East Anglia ONE North and East Anglia TWO Offshore Windfarms

Applicants' Comments on East Suffolk Council's Deadline 9 Submissions

Document Reference: ExA.AS-1.D10.V1

Date: 6th May 2021

**Figure: 29.37f**  
**Viewpoint 5: Public Right of Way, near Moor Farm**

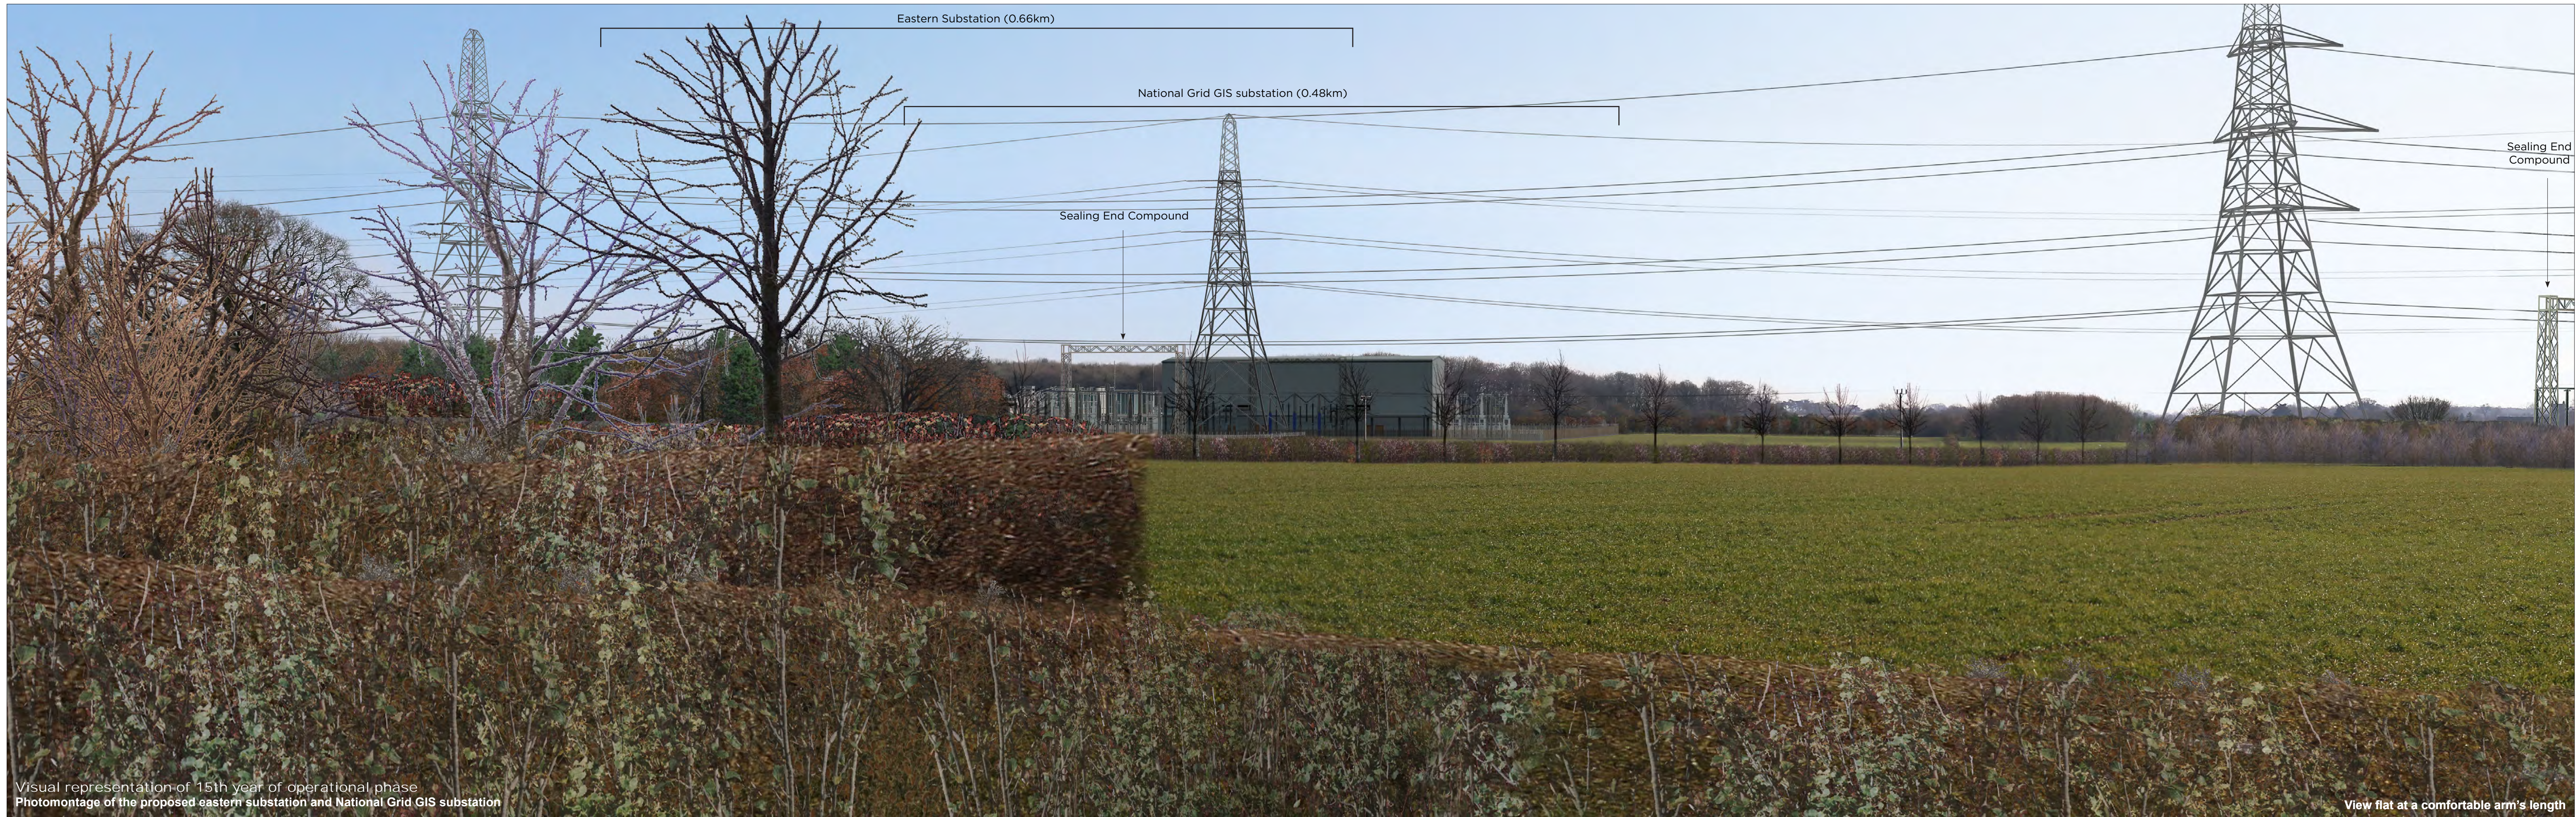
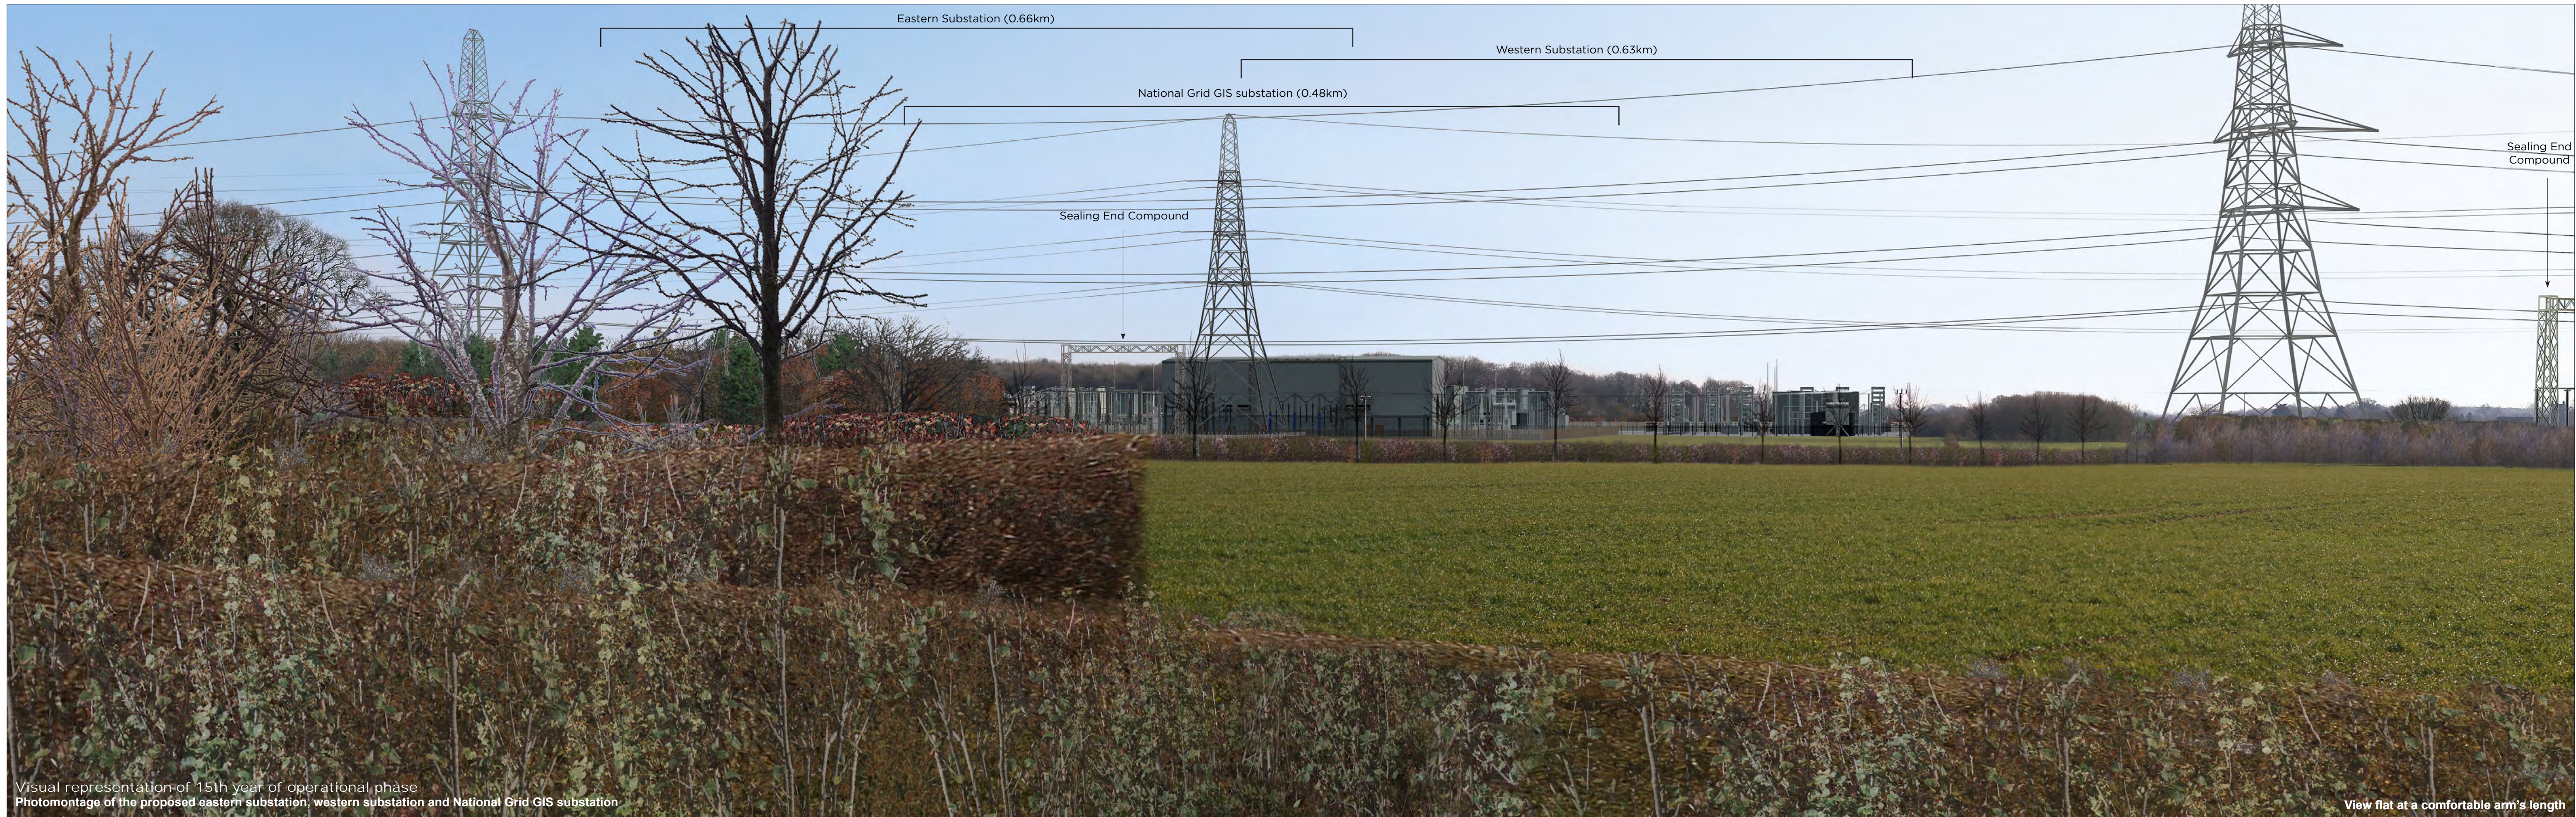
National Grid GIS Substation Photomontages		
47	The provision of updated photomontages showing the Gas Insulated Switchgear (GIS) Substation option are welcome. The	Noted. The Applicants maintain that, on balance, they consider an Air-Insulated Switchgear (AIS) solution for the National Grid substation to be a worst-case

ID	ESC Comment	Applicants' Comments
	<p>overall footprint of the National Grid substation is significantly smaller although the building structures associated with this technology would be taller and have a larger solid mass than the Air Insulated Switchgear (AIS) substation option.</p> <p>The Environmental Statements are based on the use of an AIS National Grid substation, and although the photomontages are useful, no equivalent assessment to that within the Environmental Statements has been provided in relation to a GIS National Grid substation. Without a full assessment of the GIS option, it is not possible for ESC to fully compare the impacts of the two technologies and assess the degree to which one technology is beneficial over the other. The lack of a full assessment of the GIS option also limits the Examining Authority's ability to recommend to the Secretary of State that one technology should be favoured over another and prevents the ability for only the GIS option to be consented by the DCOs.</p> <p>Based on the information available, the comments contained within paragraphs 14.13 to 14.14 of the Local Impact Report (REP1-132) remain relevant.</p>	<p>scenario, given the area of the required footprint and associated spread of electrical equipment. As such, and in line with the Rochdale envelope approach to assessing potential environmental impacts, an assessment of landscape and visual effects has been undertaken based upon an AIS solution for the National Grid substation as presented within Chapter 29 of the ES (APP-077) and the Landscape and Visual Impact Assessment Addendum submitted at Deadline 4 (REP4-031).</p> <p>In recognition of the evolution of design commitments as detailed within the Substations Design Principles Statement (REP8-082), the Applicants intend to undertake an assessment of a Gas-Insulated Switchgear (GIS) National Grid substation and will submit this at Deadline 11.</p>
